Application number: 2024/93458	
What is the application for?:	Erection of residential development for 62 dwellings including grouting remedial
Address of the site or building:	land at, Cliff Hill, Denby Dale, Huddersfield, HD8
Postcode:	YO1 0LT

Type of comment: An objection	
Do you wish your comments to be published on the website anonymously?	Yes
<p>I wish to strongly object. The proposal is still for a coal mine!</p> <p>In addition:</p> <ul style="list-style-type: none"><li>- FLOOD RISK The application form still says the scheme will not increase flood risk, but about one fifth of the road area will discharge surface water onto Cumberworth Lane which already runs like a river in heavy rain, as does Wakefield Road further on. The drains here are already failing. There are no details of the 'attenuation tank', and the calculations do not seem to address changing patterns of rainfall due to climate change.</li><li>- The outflow from the attenuation tank now goes into the existing 'water course' not sewers, but this is a seasonal ditch, which has recently been culverted under the Springhead Gardens access road (was allowance made here for additional through-flow?), and may well be t

SF3282 TPP01 Tree Protection Plan and Method Statement

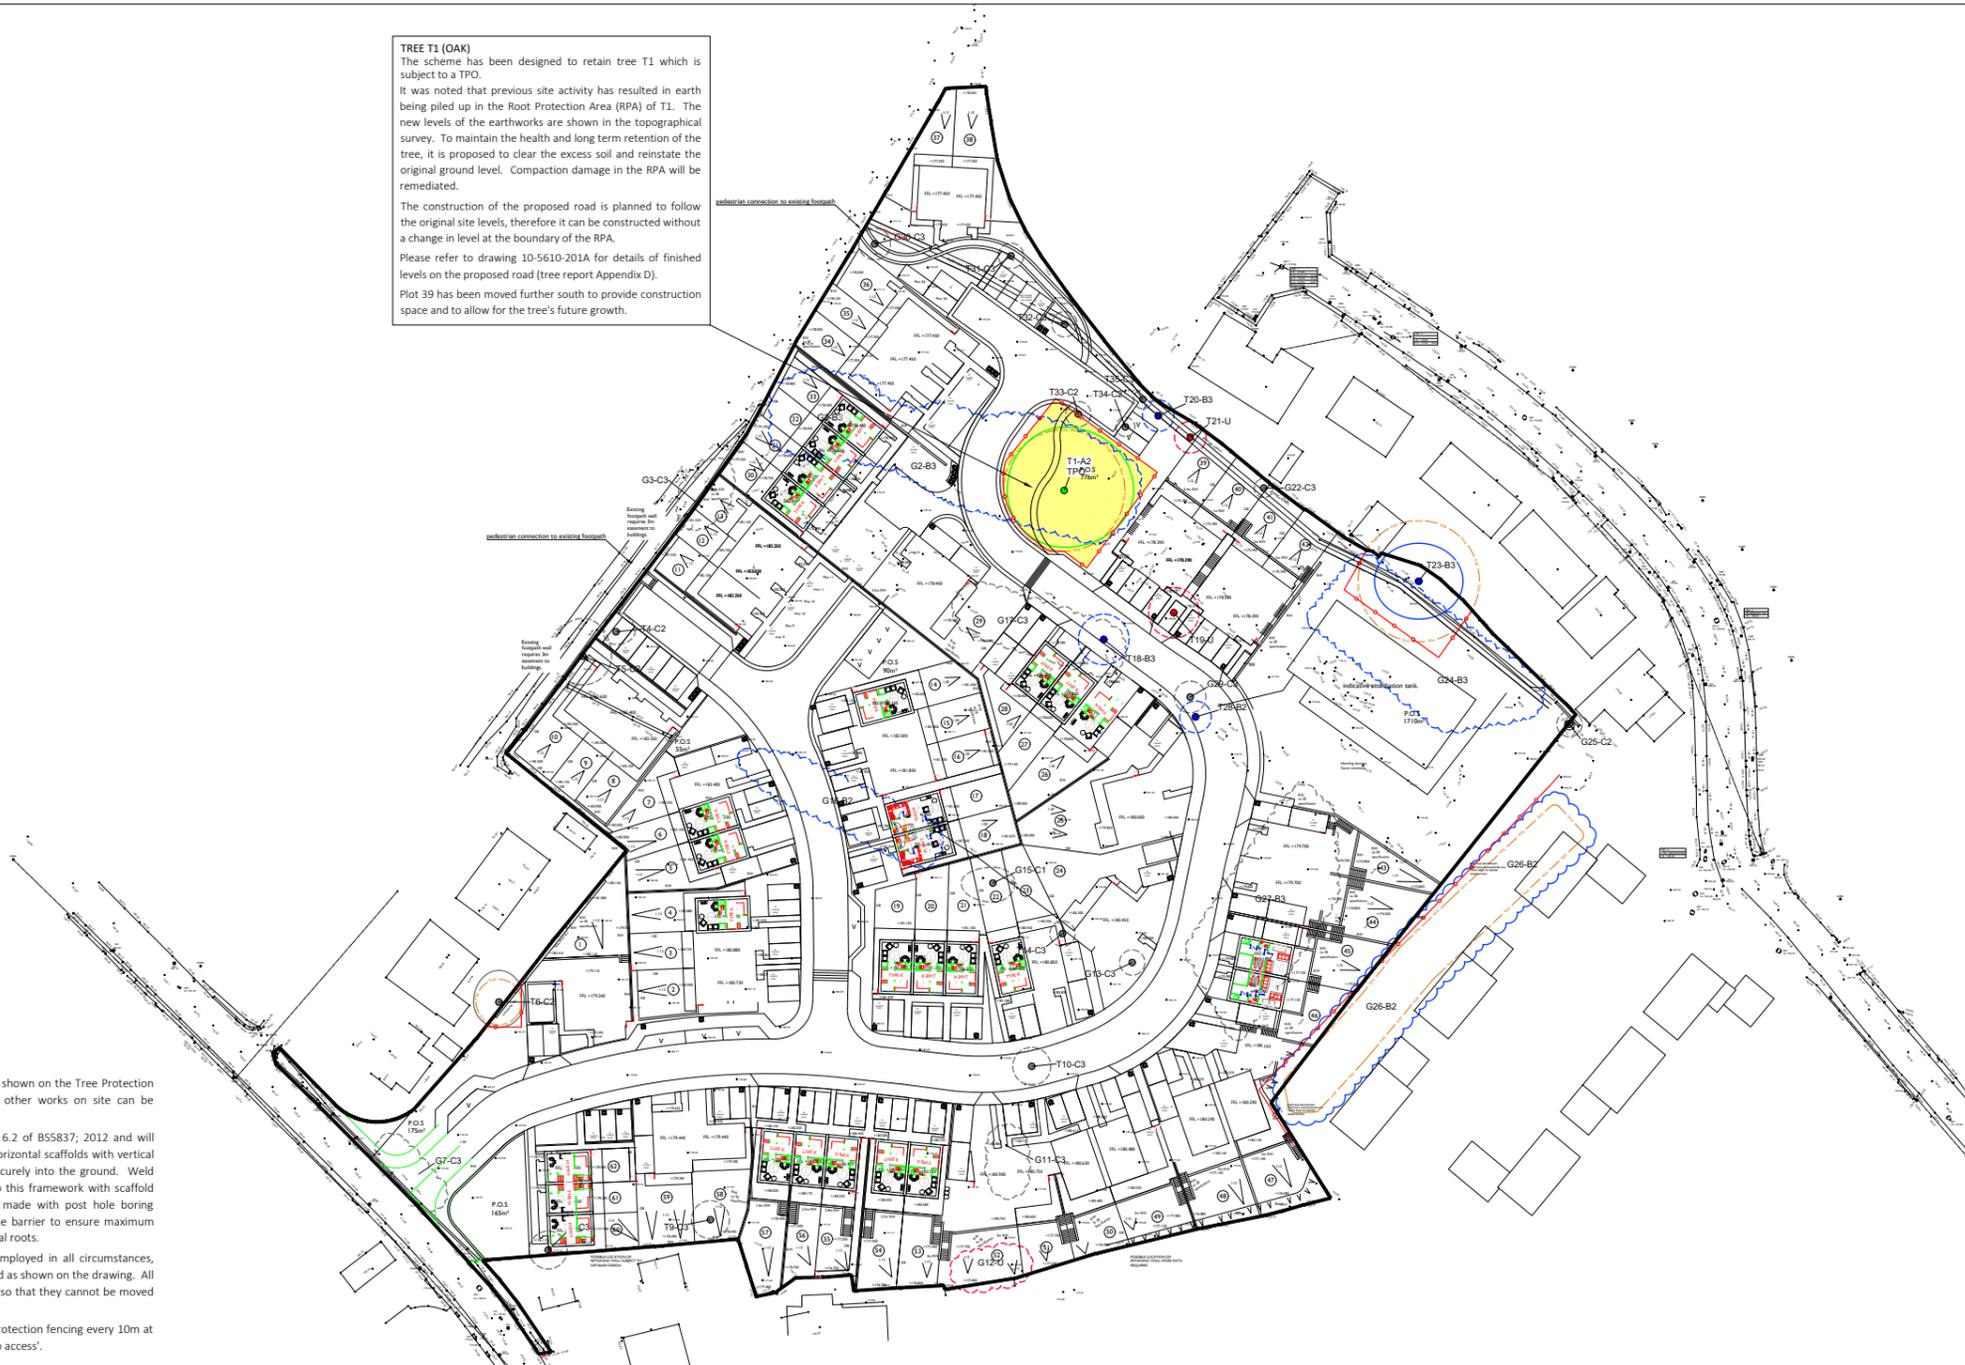
- A wiggly footpath is placed within the root zone of the TPO Oak tree – will cause damage to the tree – why here? This is not on the 'desire line' it is just a fancy and will cause unnecessary disturbance to the TPO tree's roots.
